# ENG-SP19003-R4-PDR-redlines.pdf Markup Summary

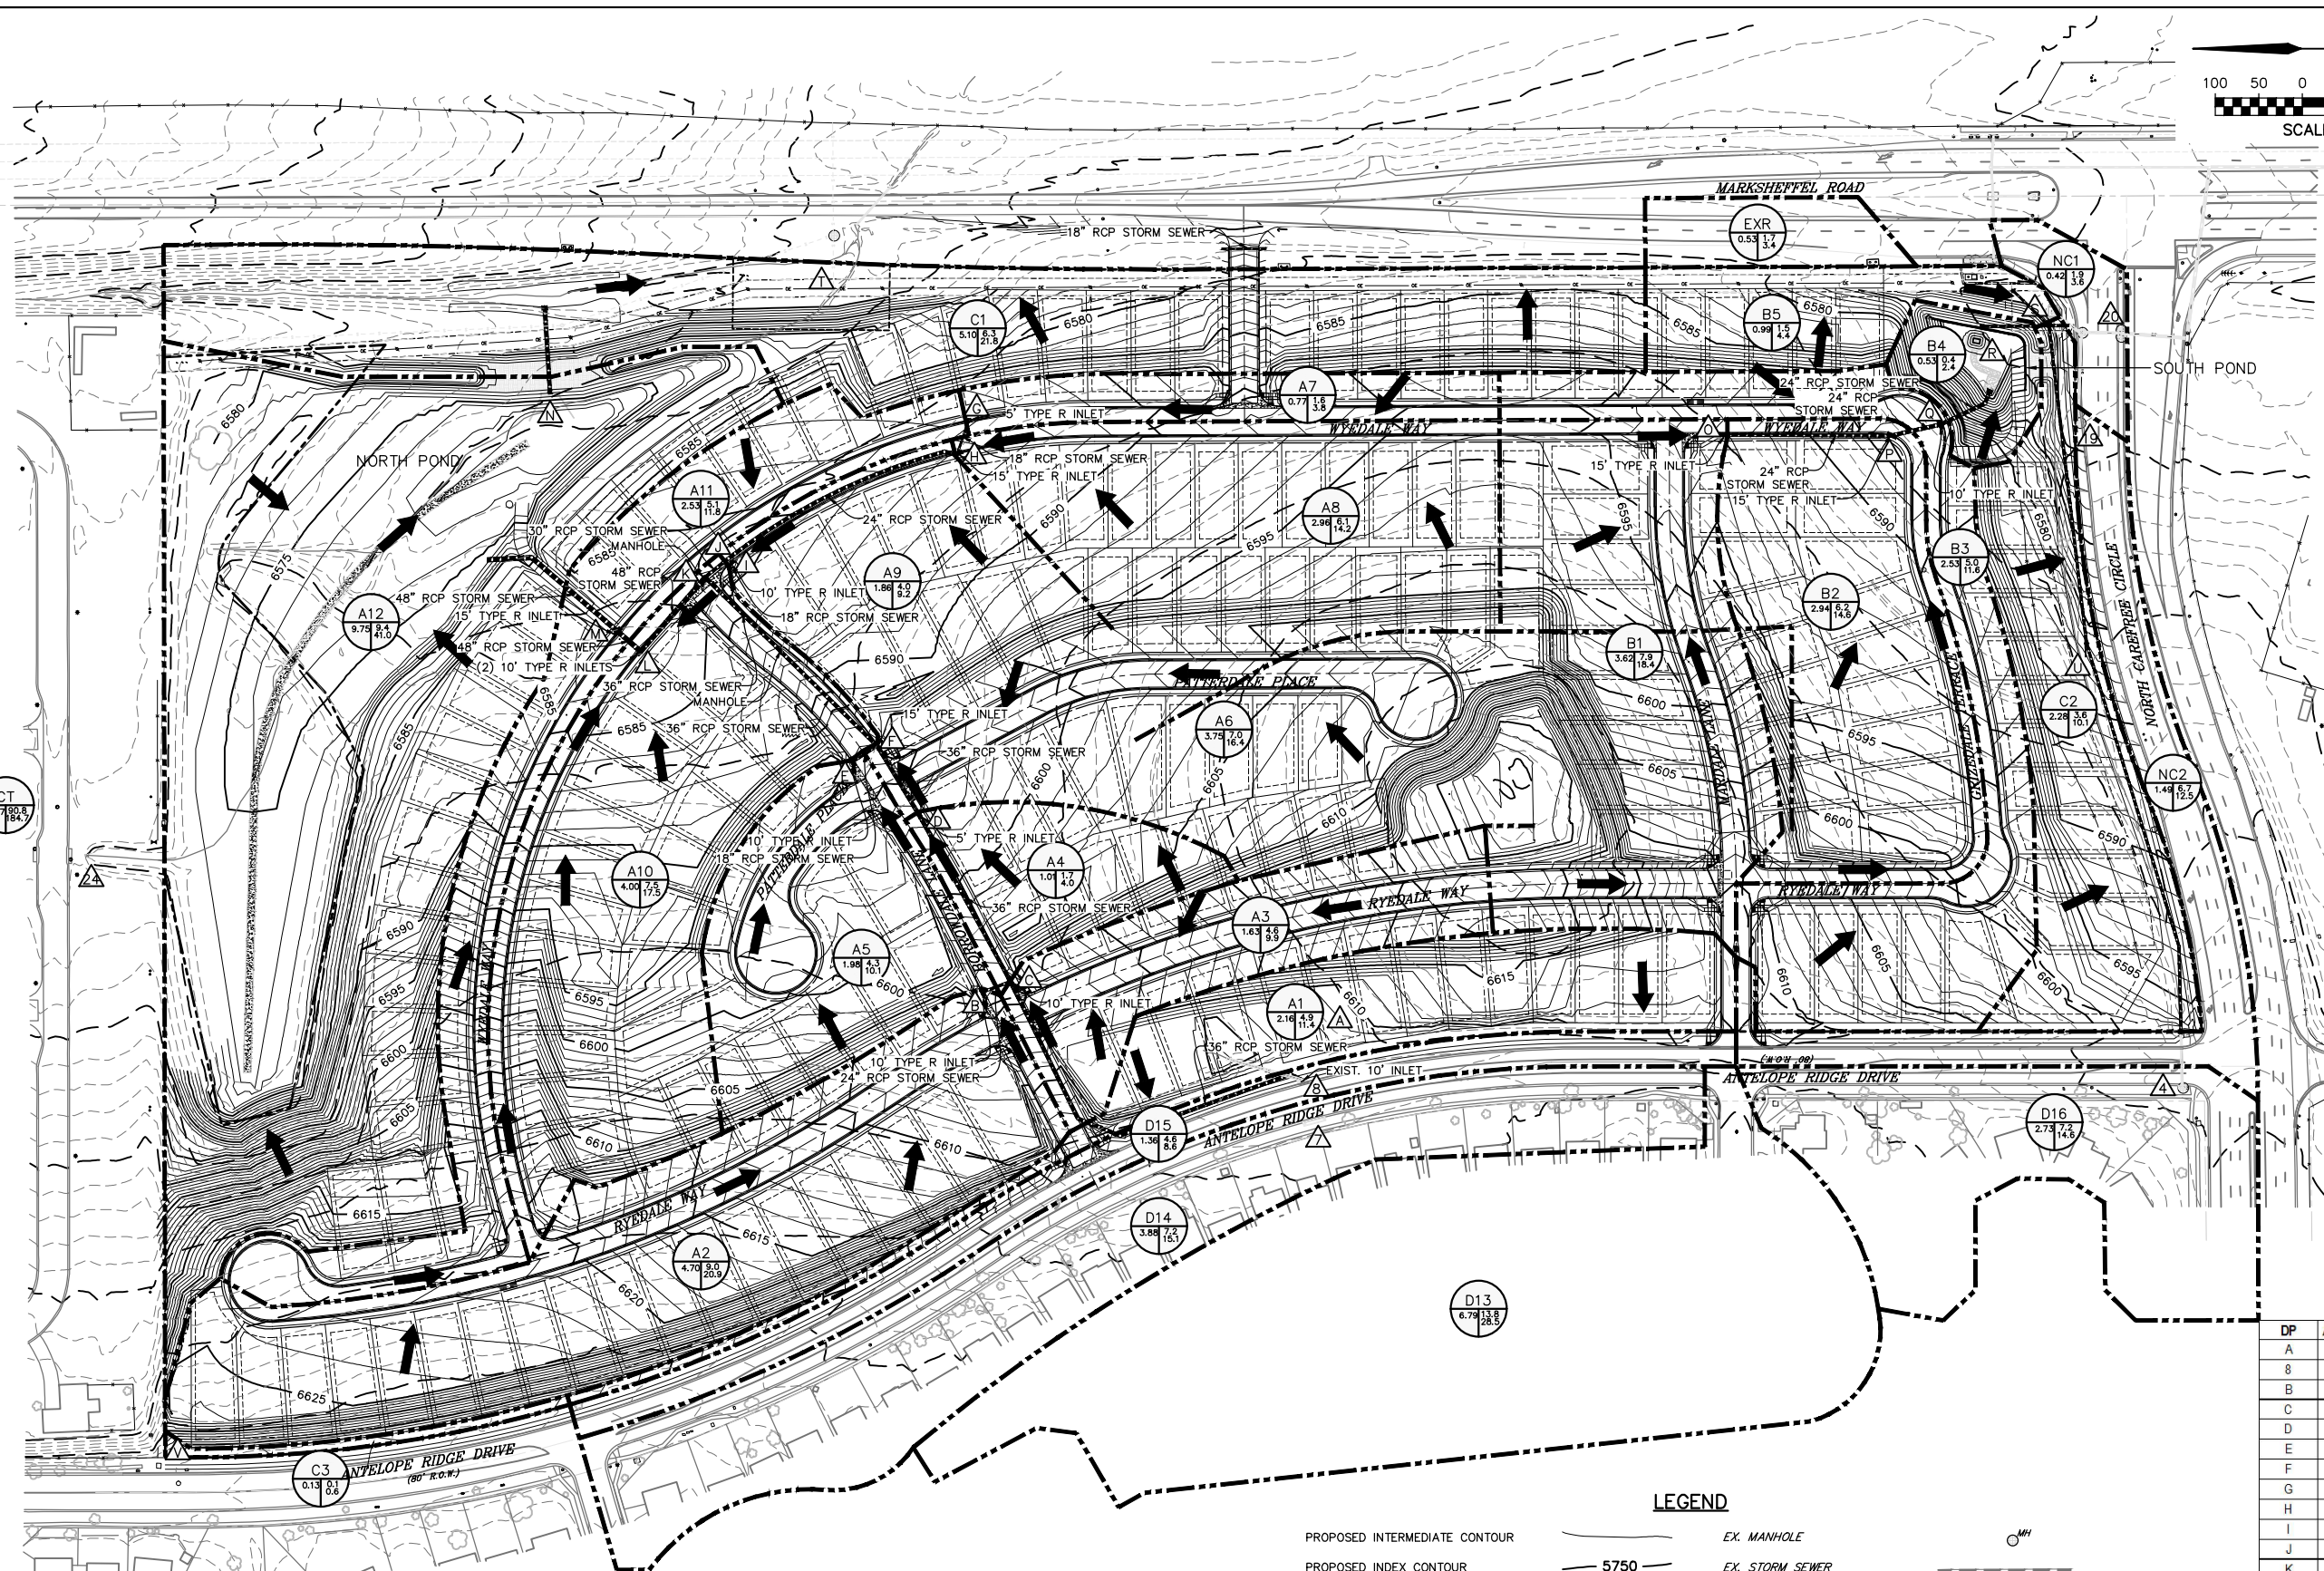
show emergency overflow path and grading

show pipe

contours are cut off - show all

Proposed 24" RCP

label inlet
